From: Amanda Scholes on behalf of Planning.Responses
Sent: 03 June 2020 08:14
To: Planning Scanning
Subject: FW: Planning Consultation on M/28/20/DOC

Engineers comments;

The level of detail supplied is currently insufficient to enable the discharge of conditions 11, 13 or 14.

Site: YAPTON POULTRY FARM
Project: MIDDLETON RESIDENTIAL
Date: 01/07/2020
Drawing: SITE VISIT DISCUSSION
APPENDIX 02

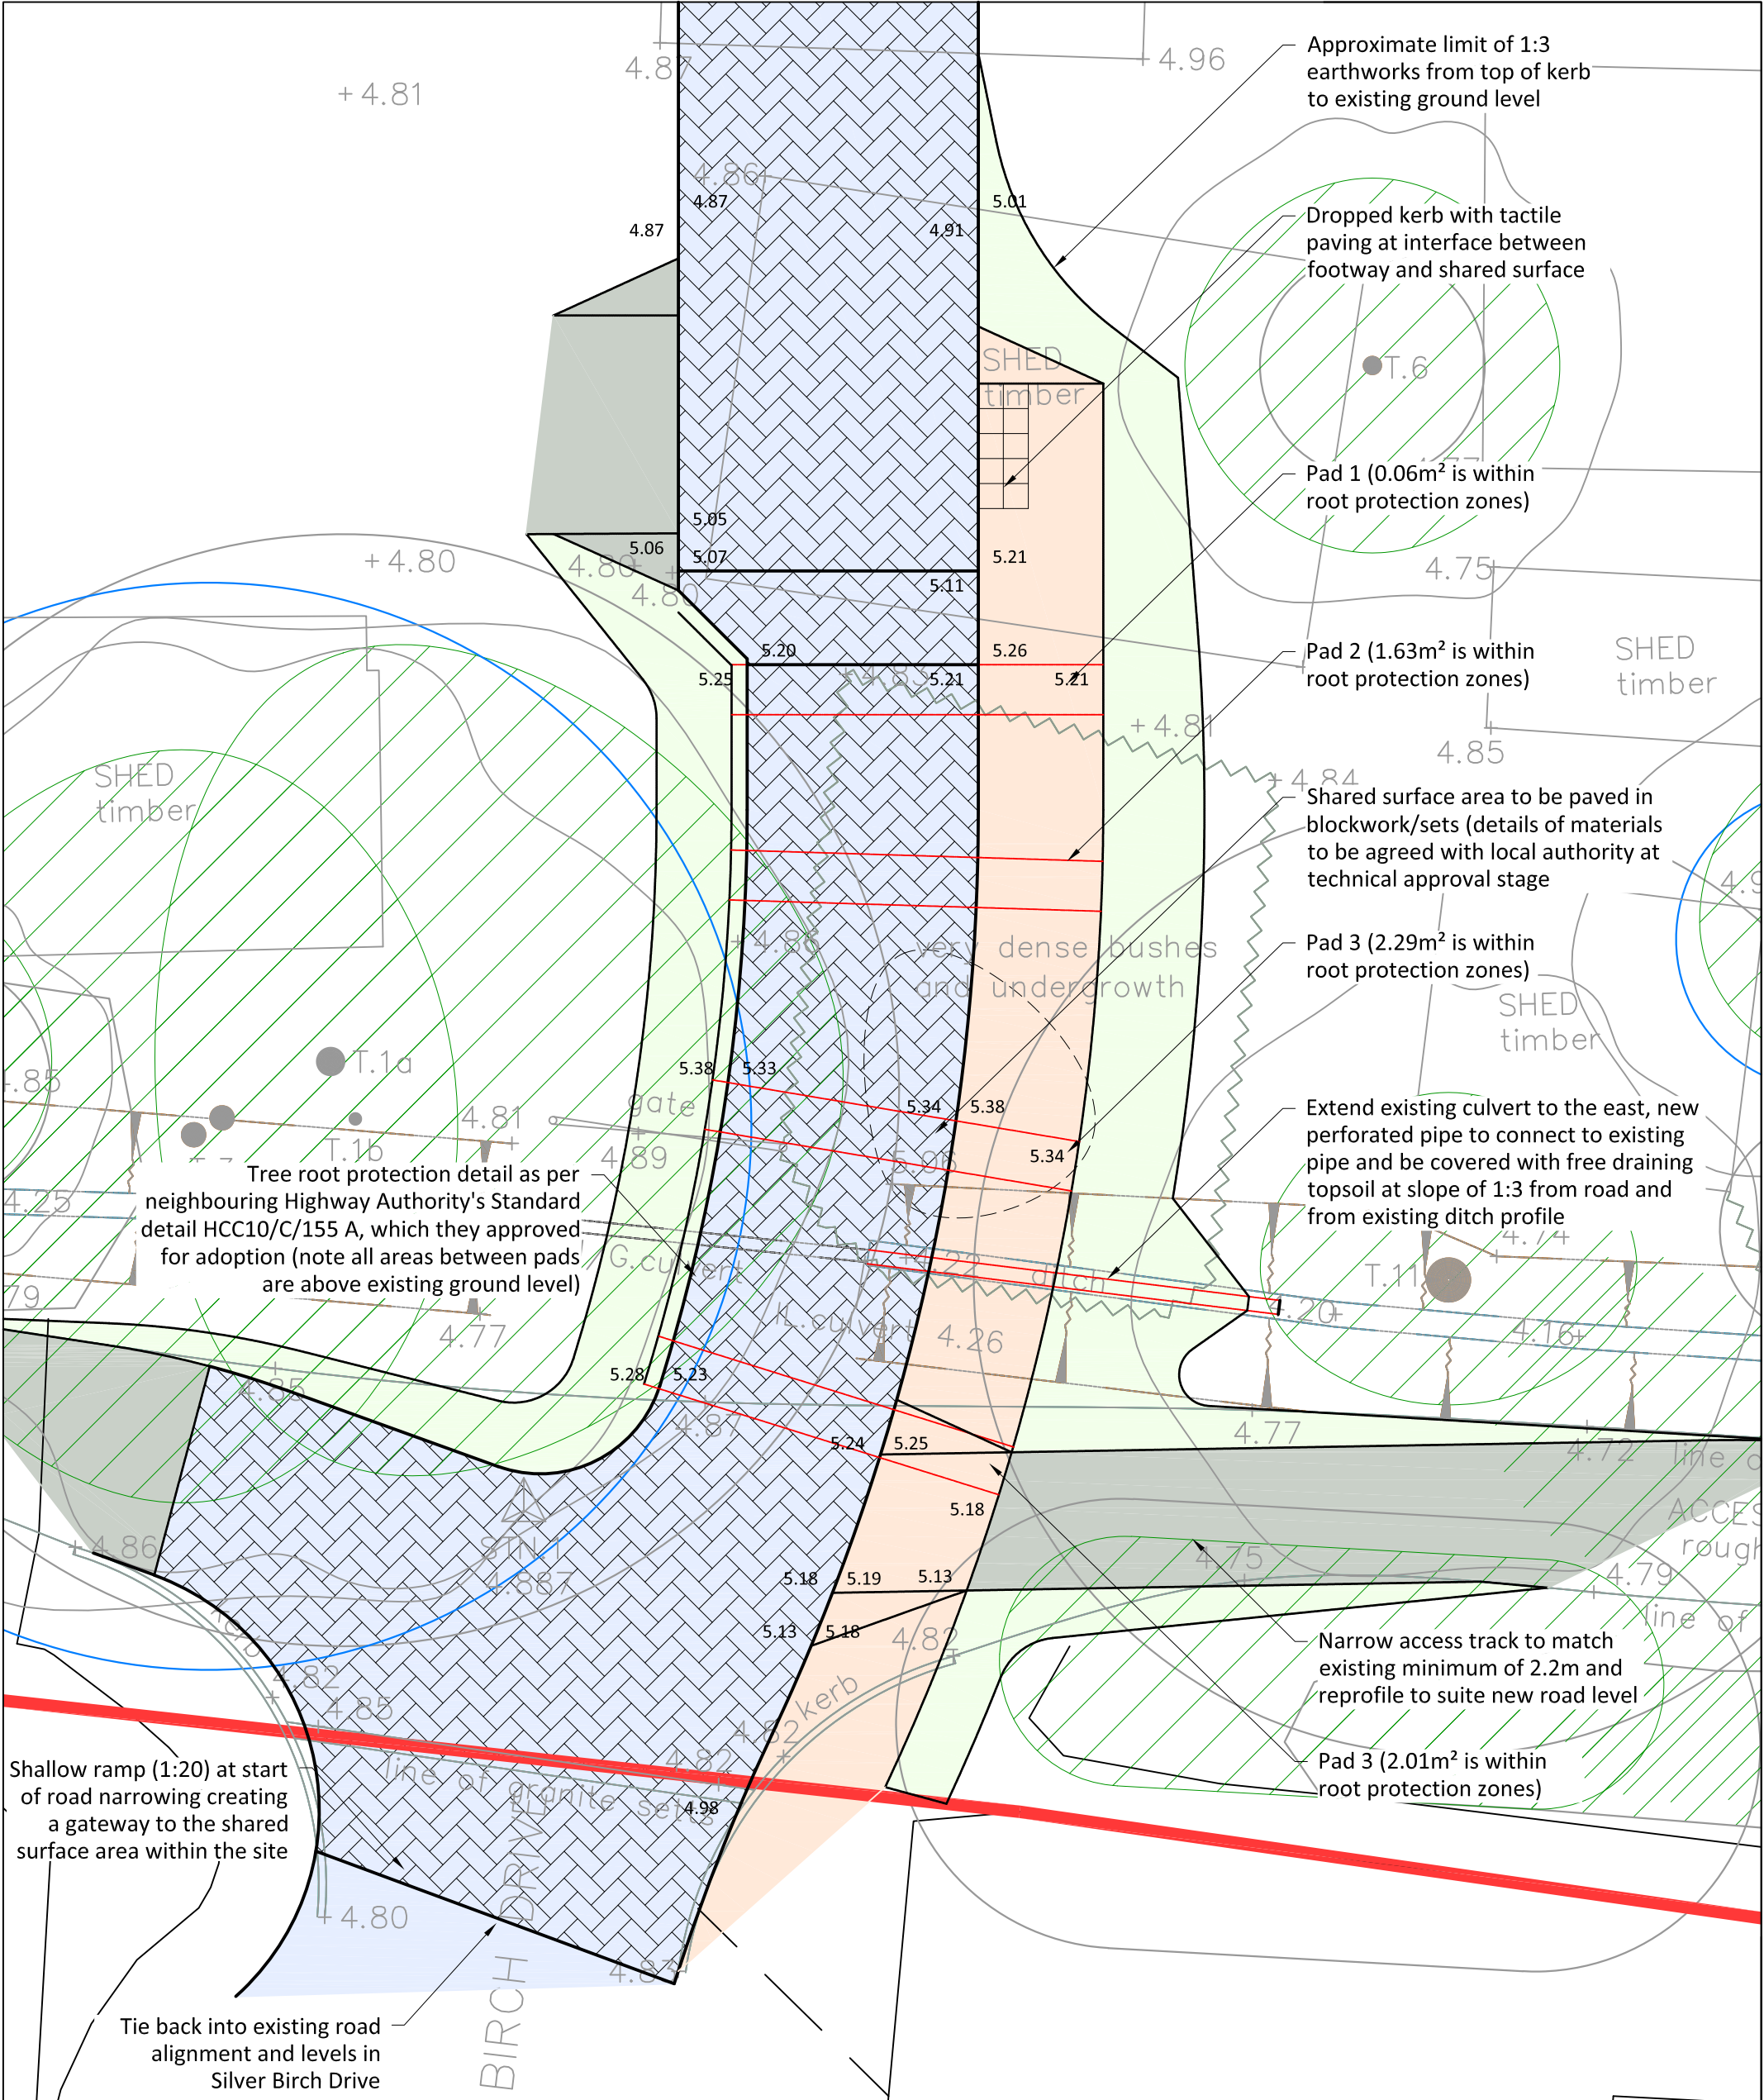
Regarding the ditches on the southern boundary, it is very likely that these will need improvements and I suggest a meeting takes place on site to look at these. Land Drainage Consent will be required for any alterations to them, including culverting and any discharge structures. This will all need to be fully detailed on the drawings.

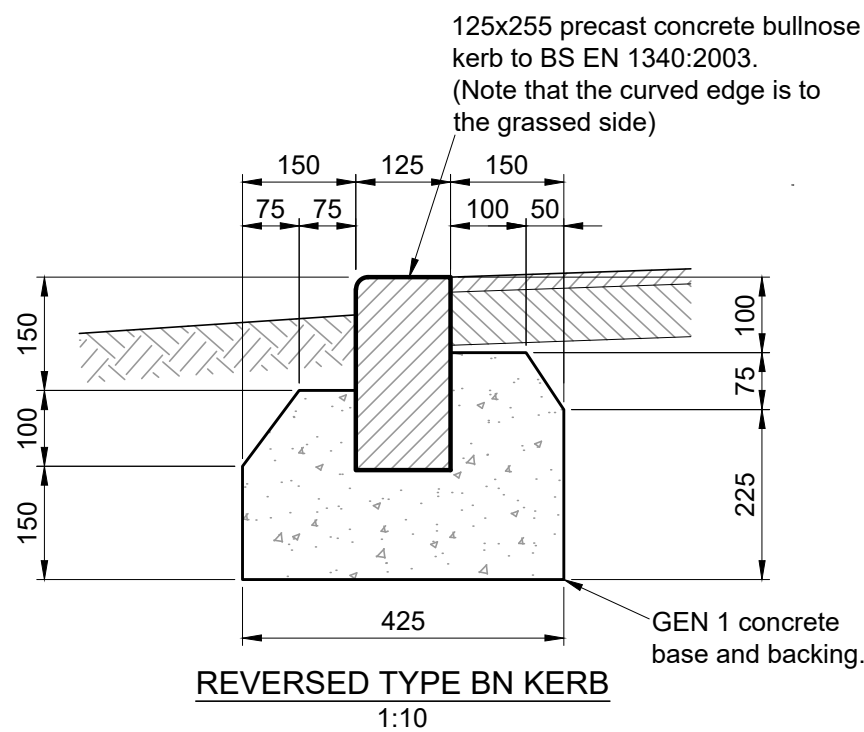
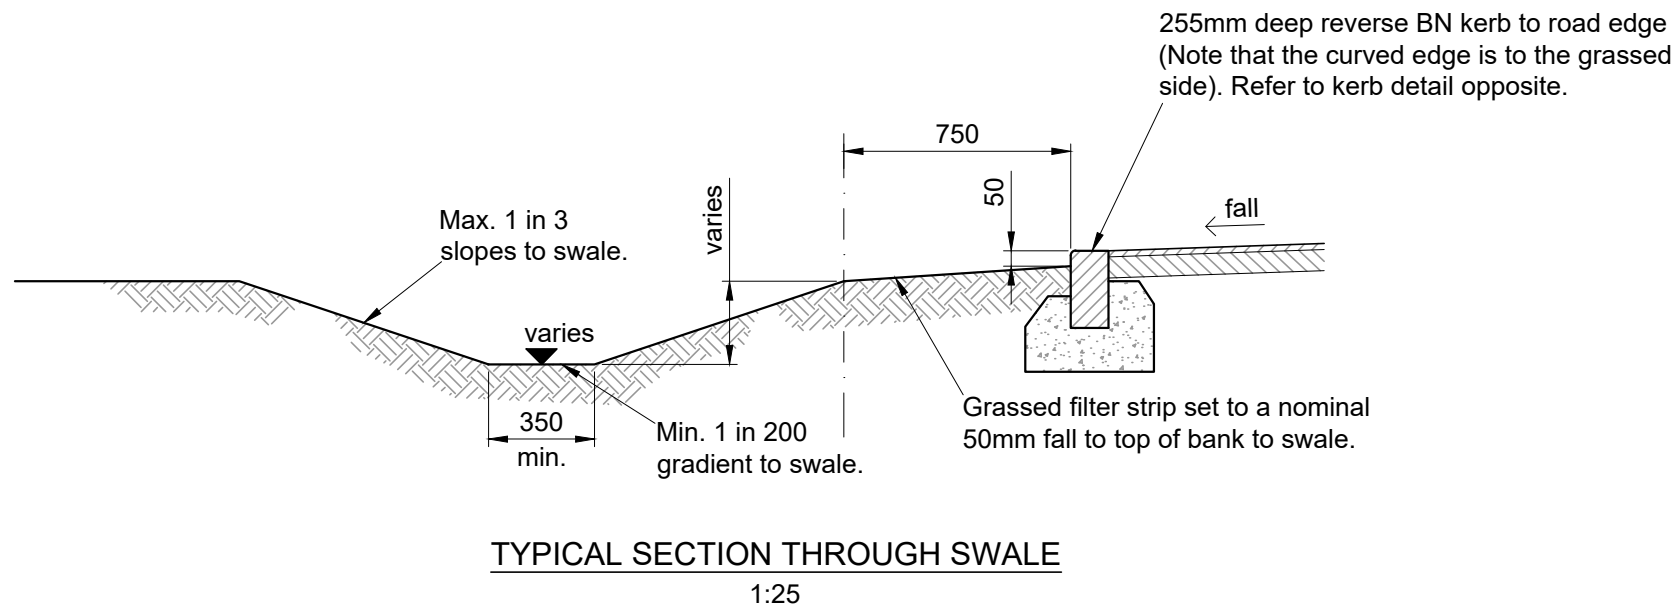
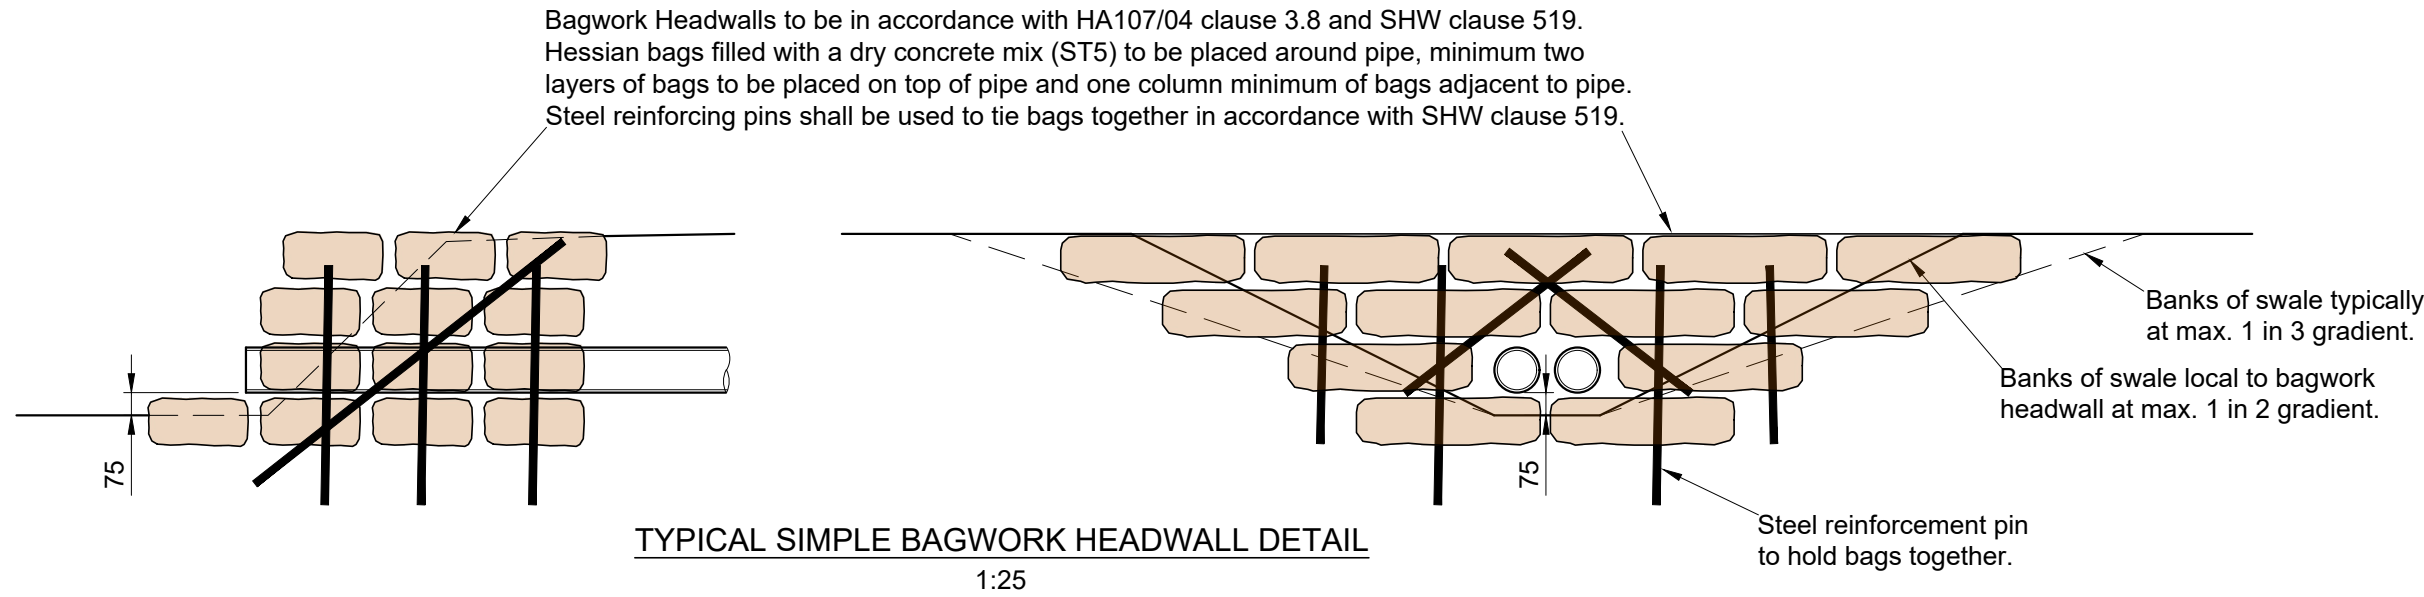
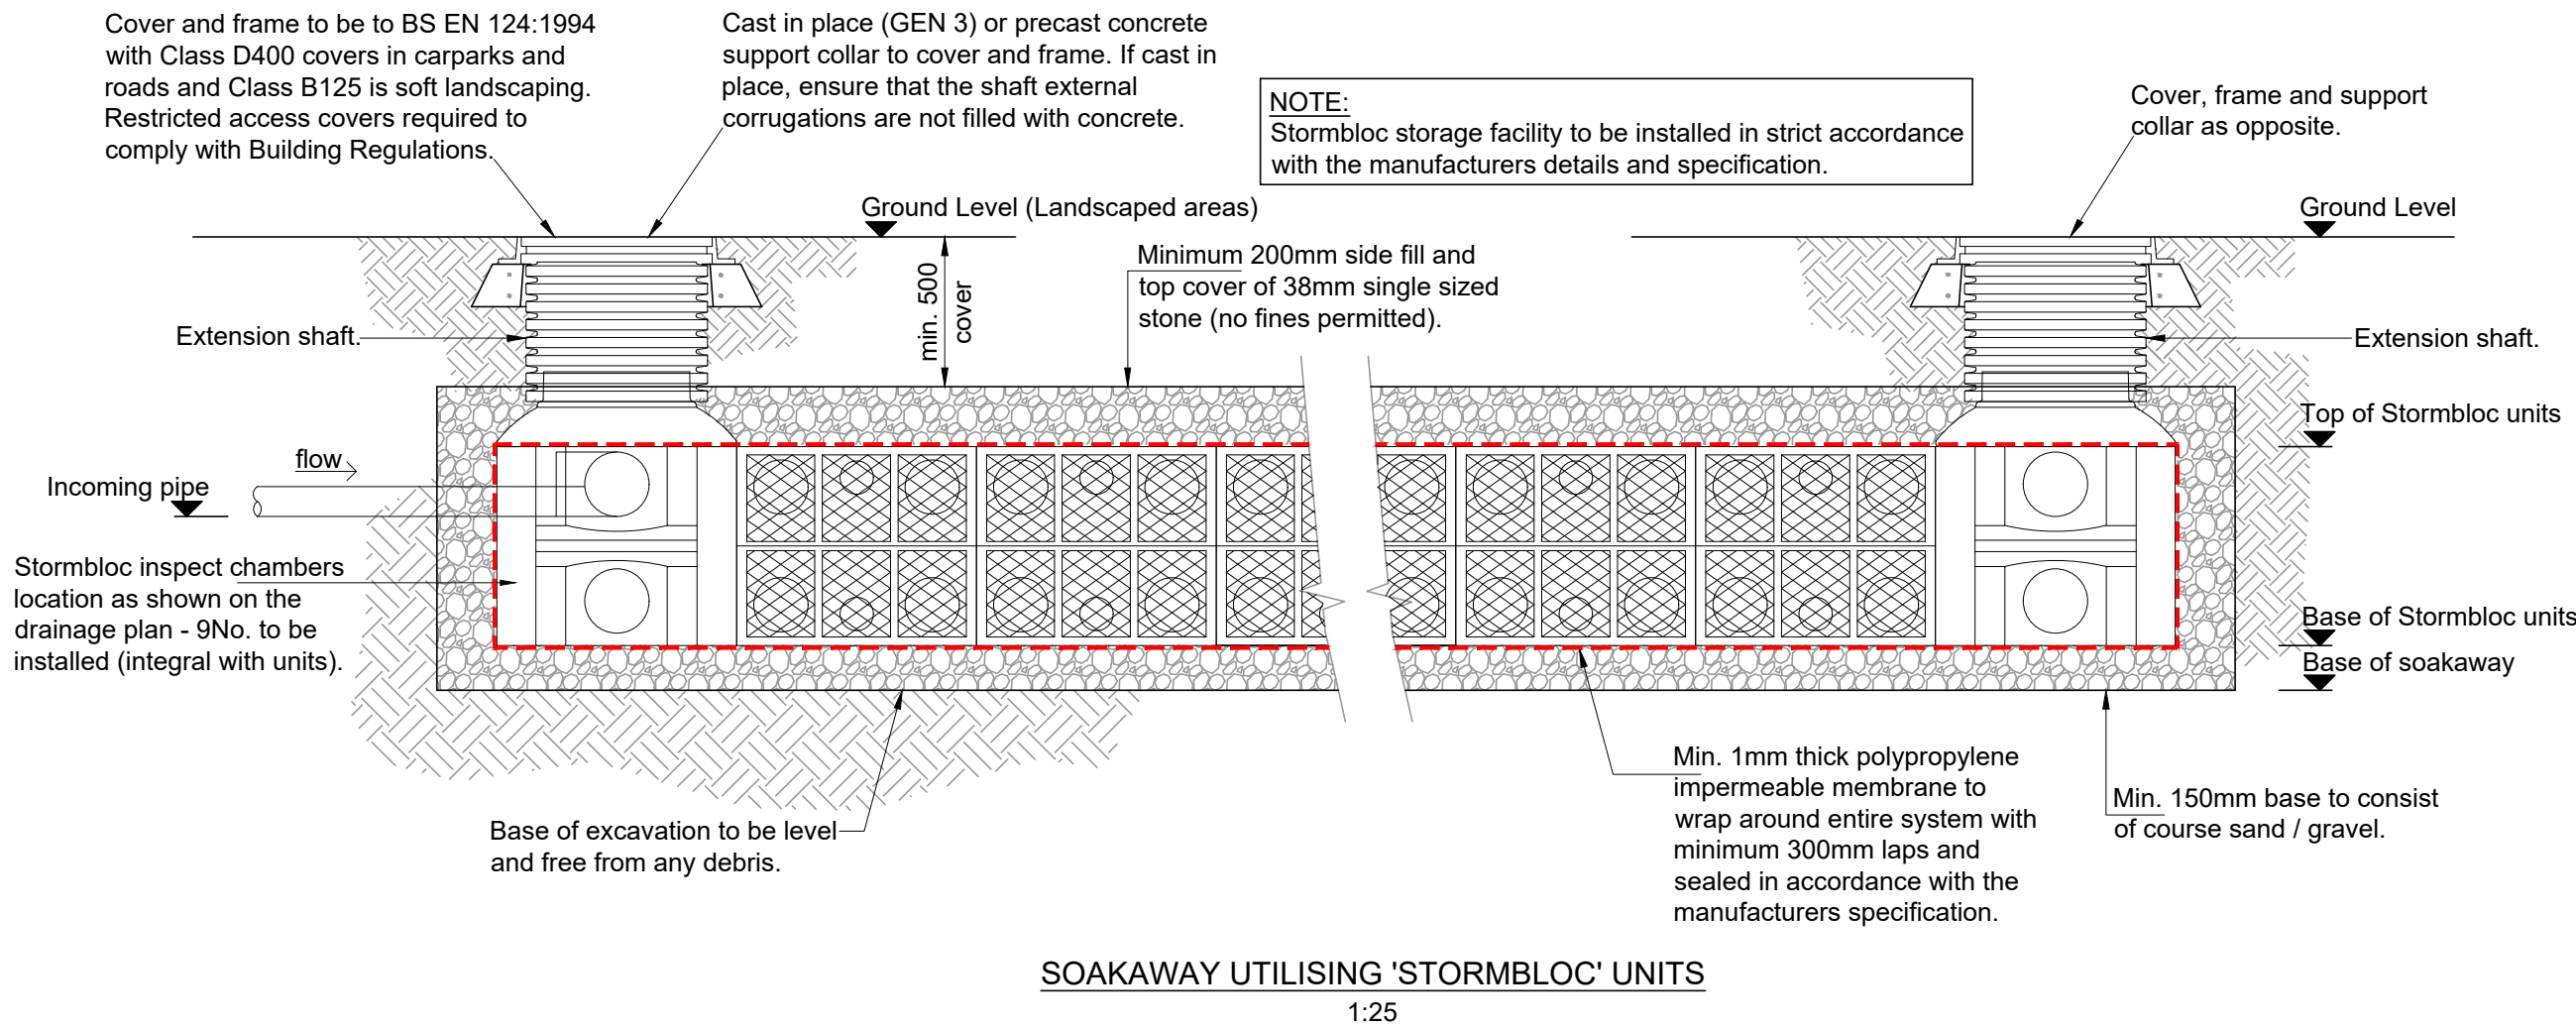
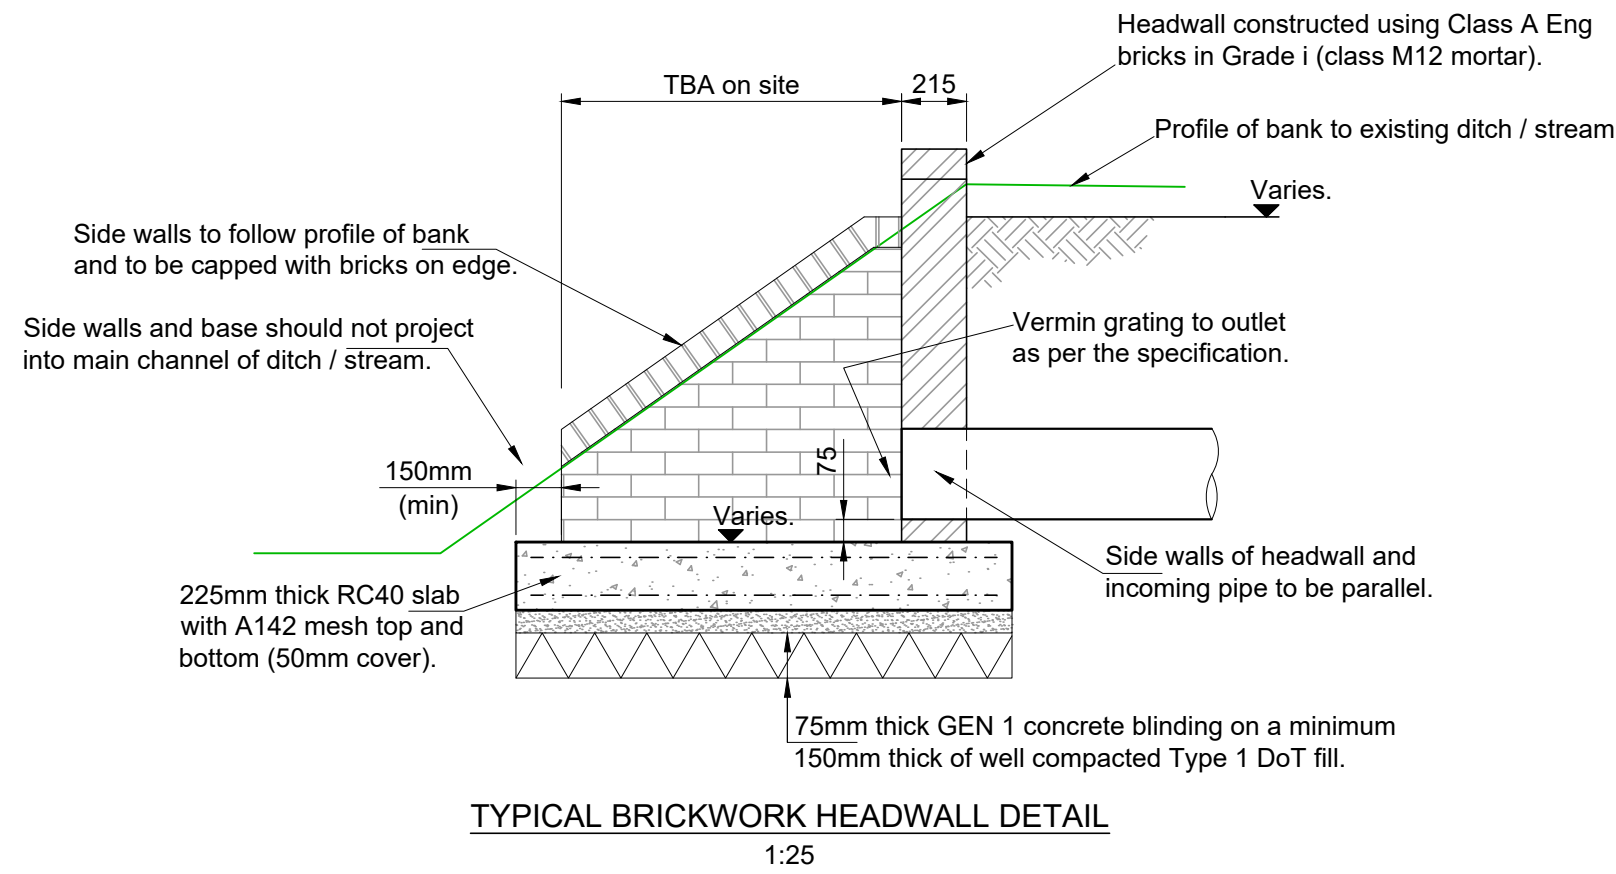
Once we have agreed the scheme principles, fully detailed plans will be required to include pipe/structure, cover levels/invert levels/base levels/diameters/gradients, etc, along with fully detailed construction drawings for all drainage elements. Please note that open suds features should be employed where possible. The current arrangement of crates is currently not desirable, since they have been arranged in manner as to use almost every piece of available space outside the root protection zones (zones will need to be confirmed), rather than achieve a more practical layout whereby membranes can be wrapped around the crates in a more suitable manner ie. reduce the number of corners. Please note that our tree officer will need to be involved in discussions in this respect due to protect the trees and the crates. Permeable paving will need to be employed where ever possible.
